Our Ref: L10002217
20 August 2026

**Arrangements for Handling Heritage Applications Direction 2021 & T&CP
(Development Management Procedure) (England) Order 2015 & Planning (Listed
Buildings & Conservation Areas) Regulations 1990**

George Hotel, St George's Square, Huddersfield, HD1 1JA
Application No. 2026/70LBC/91801/W

RF Level RF - Roof Demolition Plan
1 : 100

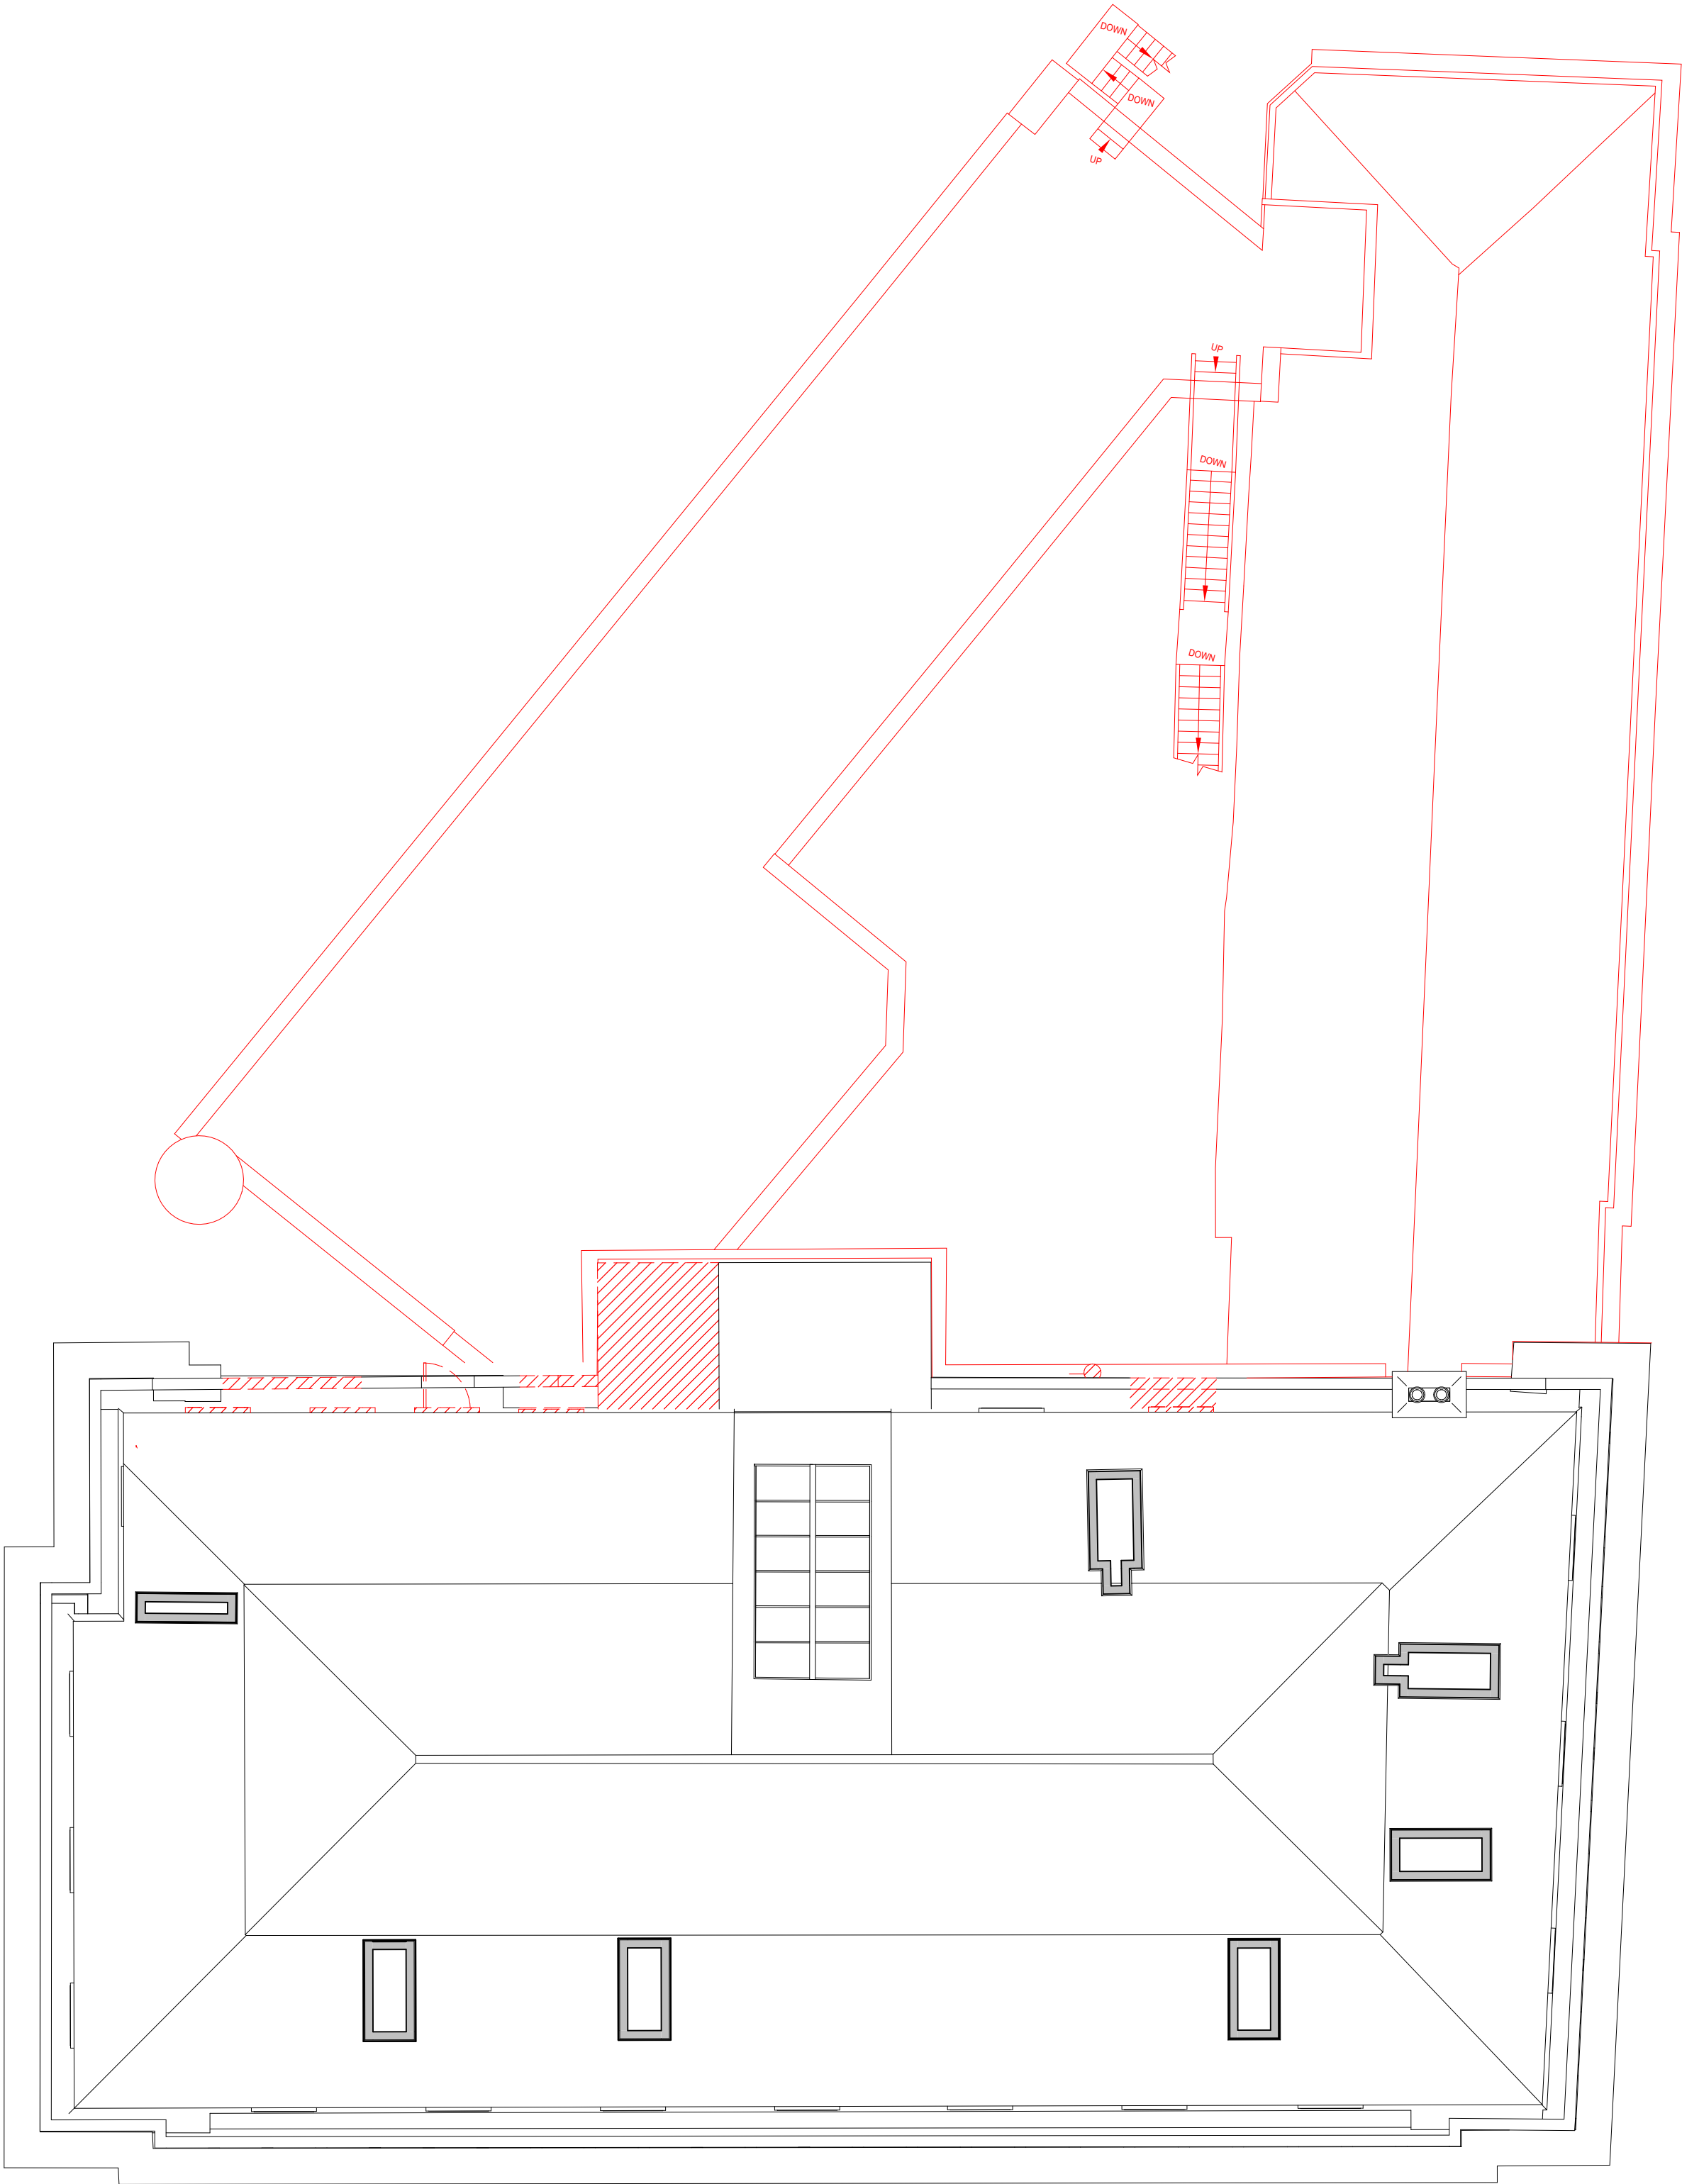
- The revised proposals include the reduction in scale of the roof top plant. In its place is a ventilation system, serving the guest bathrooms, with new circular vents to the elevations. Due to the high number of vents, the cumulative impact on architectural significance is notable. We would encourage consideration of a review of this scheme to remove or reduce the vents, particularly on the principle elevation fronting St George Square/Railway Street. Historic England's Building Services Engineers can provide support, please contact us if you would like to consider this.

- If it is not possible to remove the vents from the scheme, advice on potential mitigation should be sought from the Council's conservation advisers.

01 Level 01 - First Floor Demolition Plan
1 : 100

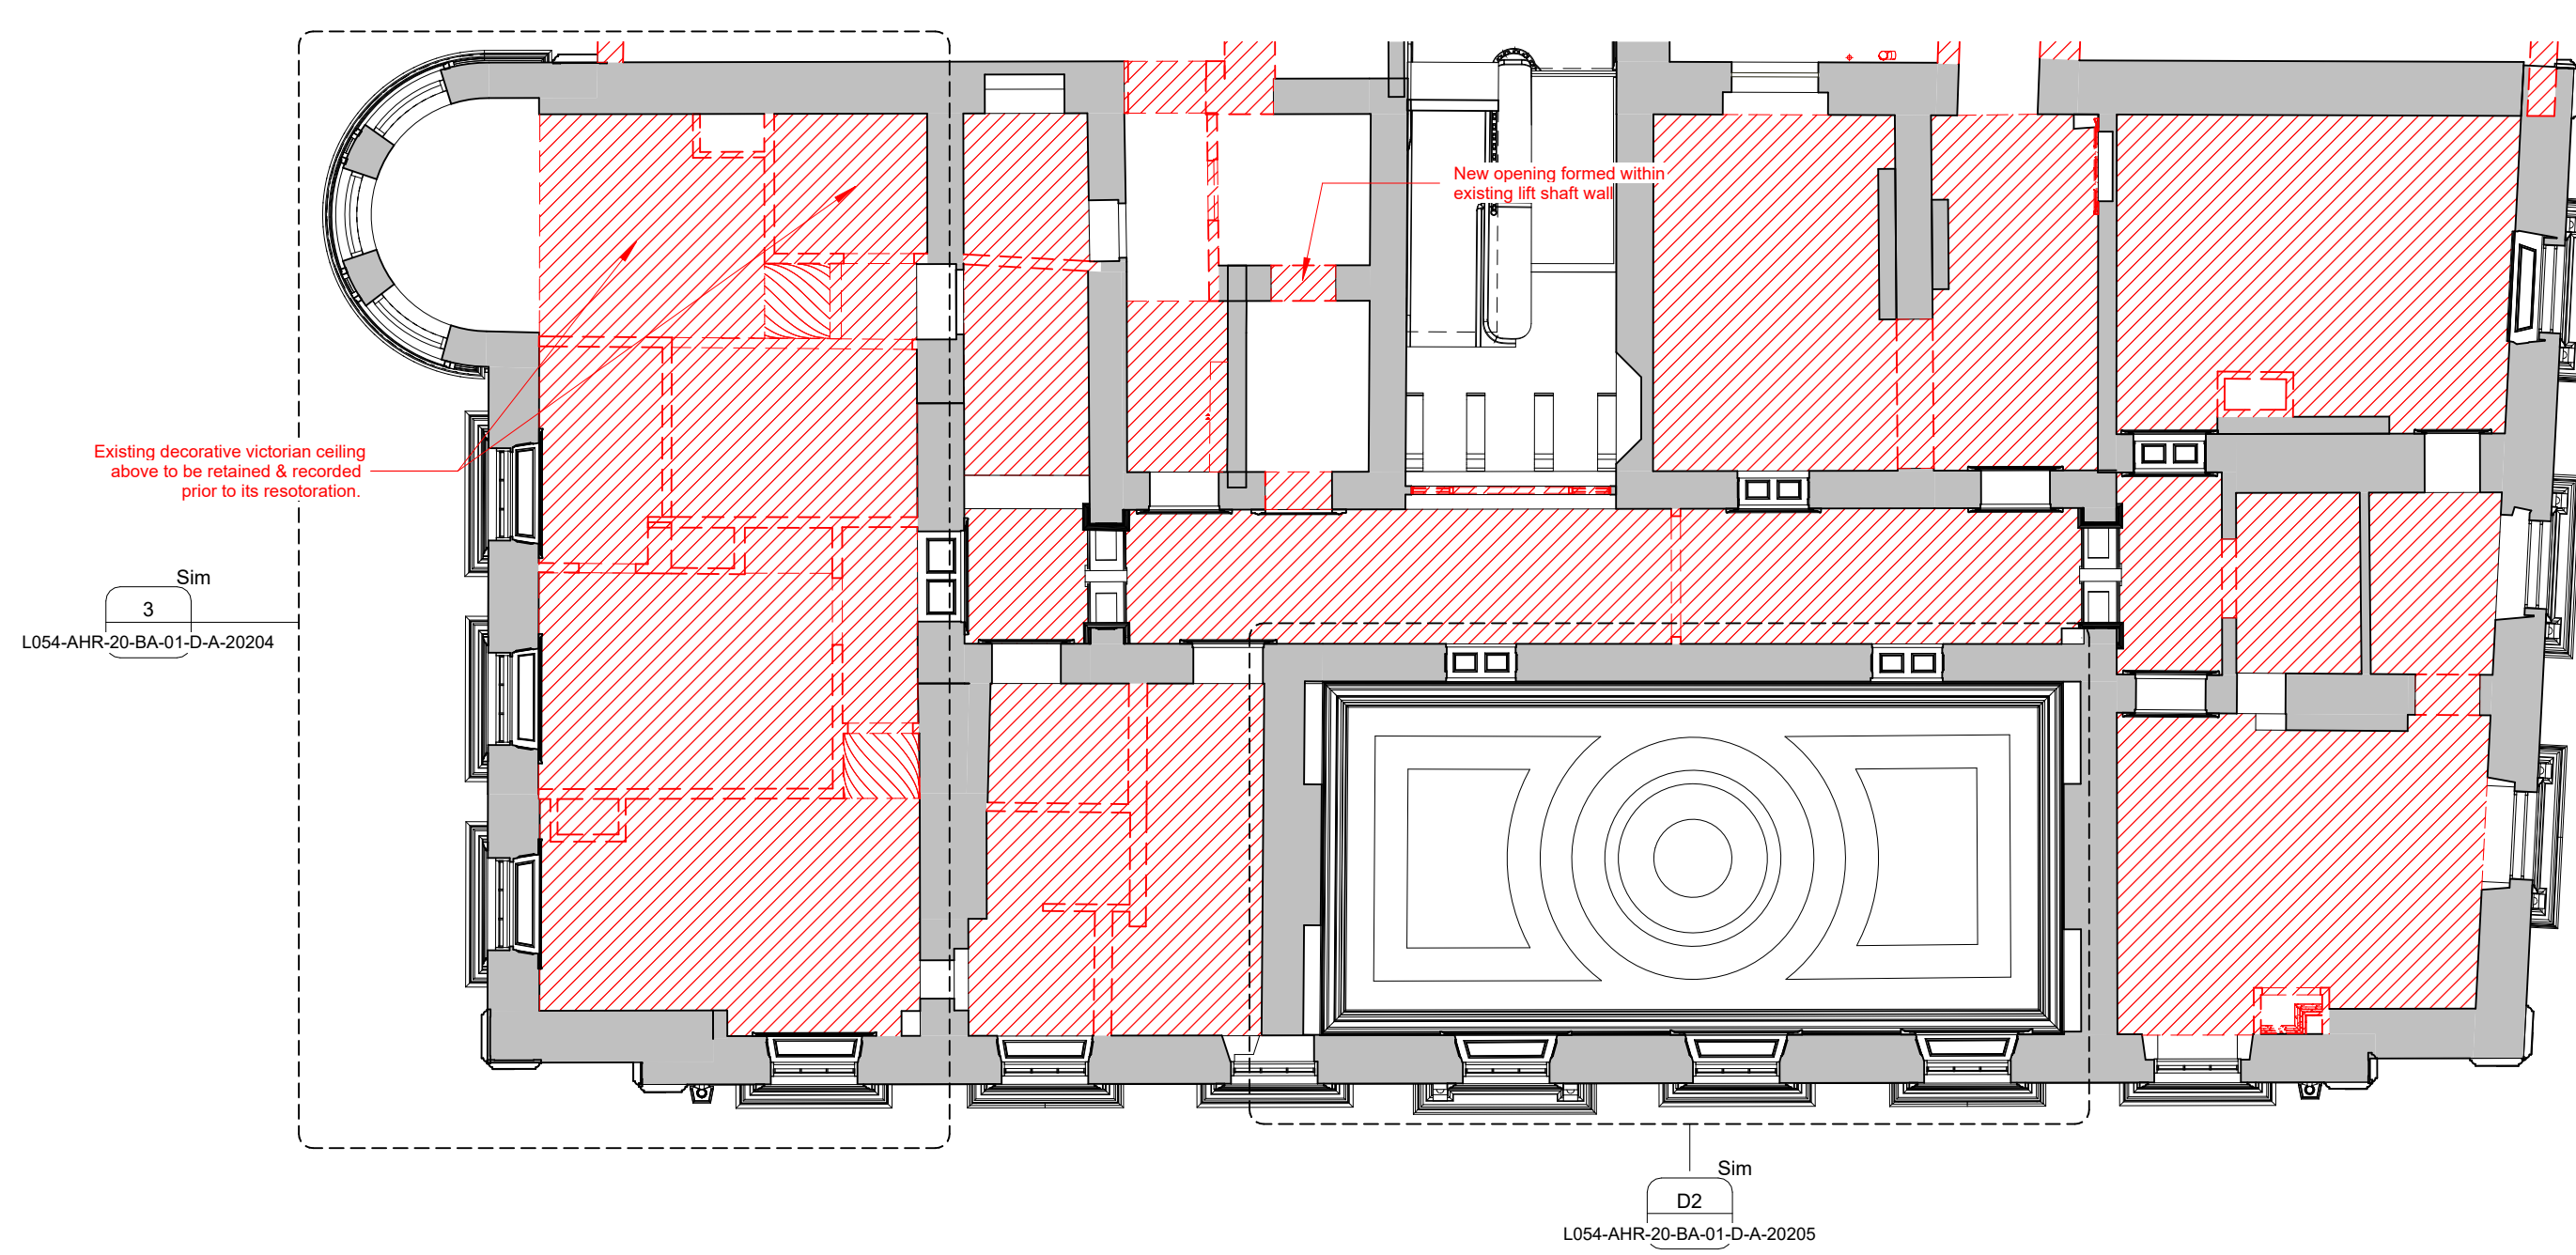
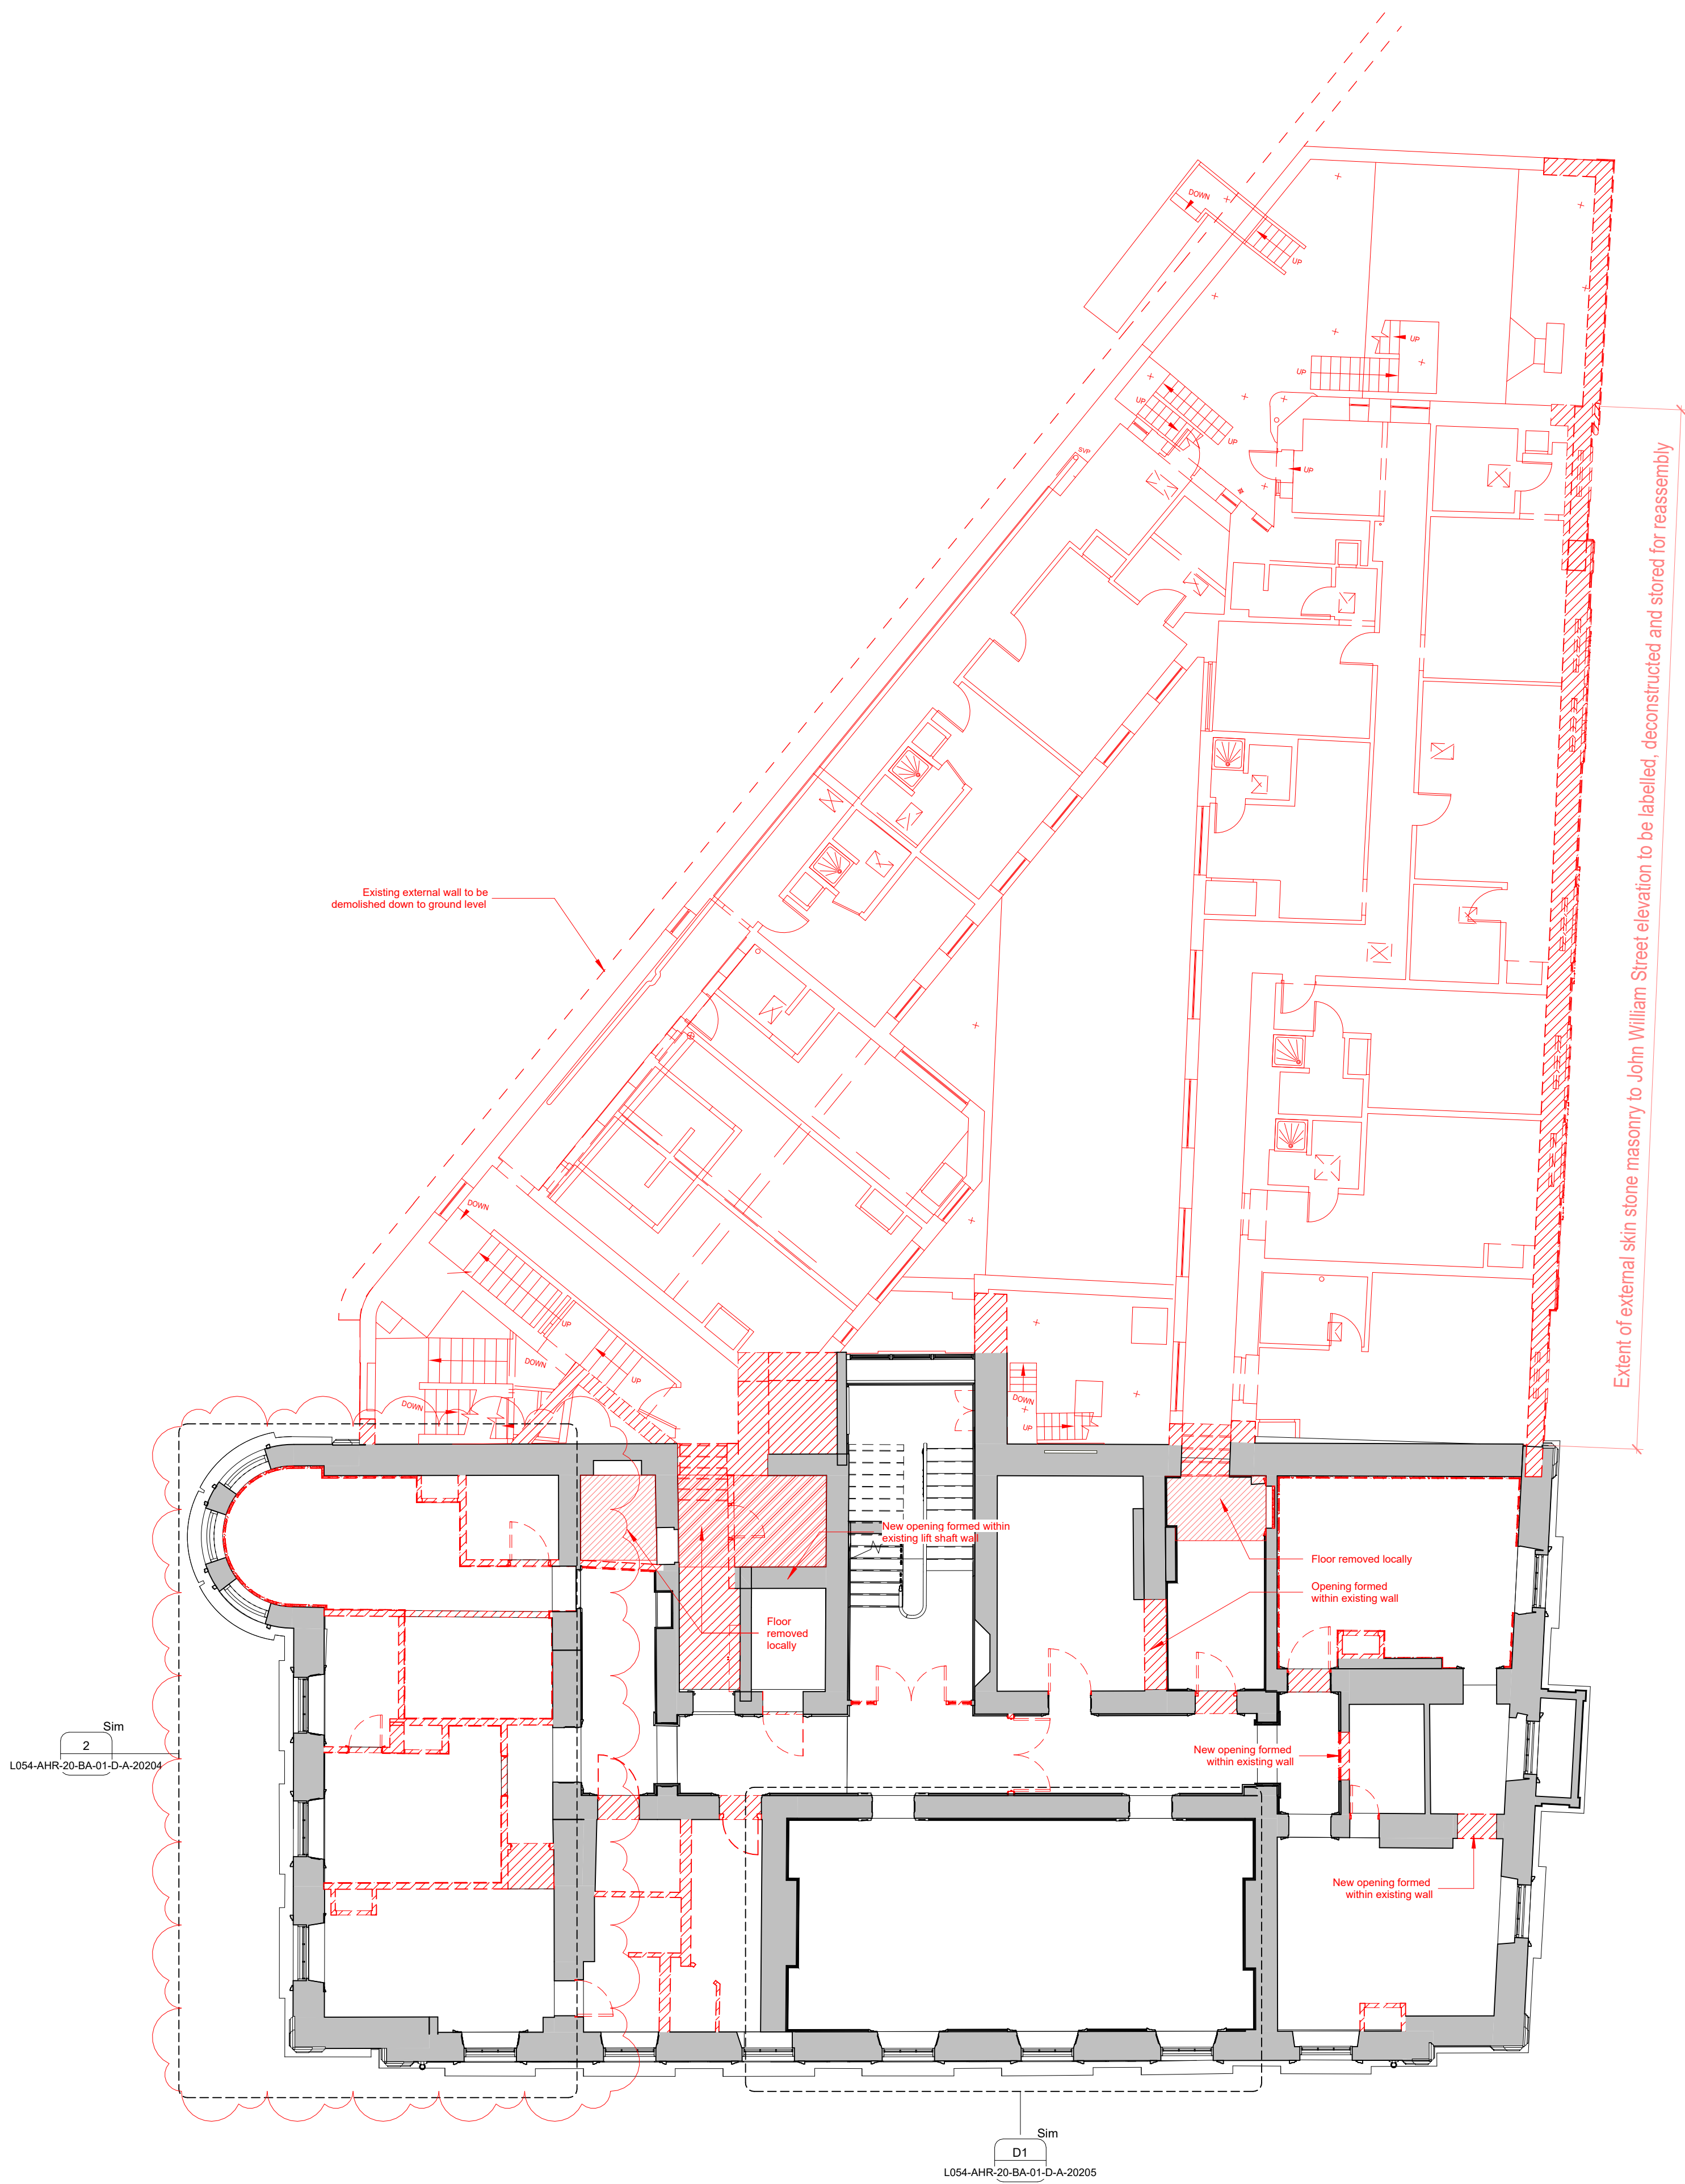
- The revised proposals will result in an increased loss of historic fabric, including features such as skirtings, doors, cornices and ceiling roses. Consideration should be given to alternative measures to allow retention of architectural features, whilst meeting the needs of the hotel. Historic England guidance is available online, such as Fire Resistance and Historic Timber Panel Doors:
<https://historicengland.org.uk/images-books/publications/fire-resistance-historic-timber-panel-doors/ife-sig-guide-fire-resistance-historic-timber-panel-doors/>.
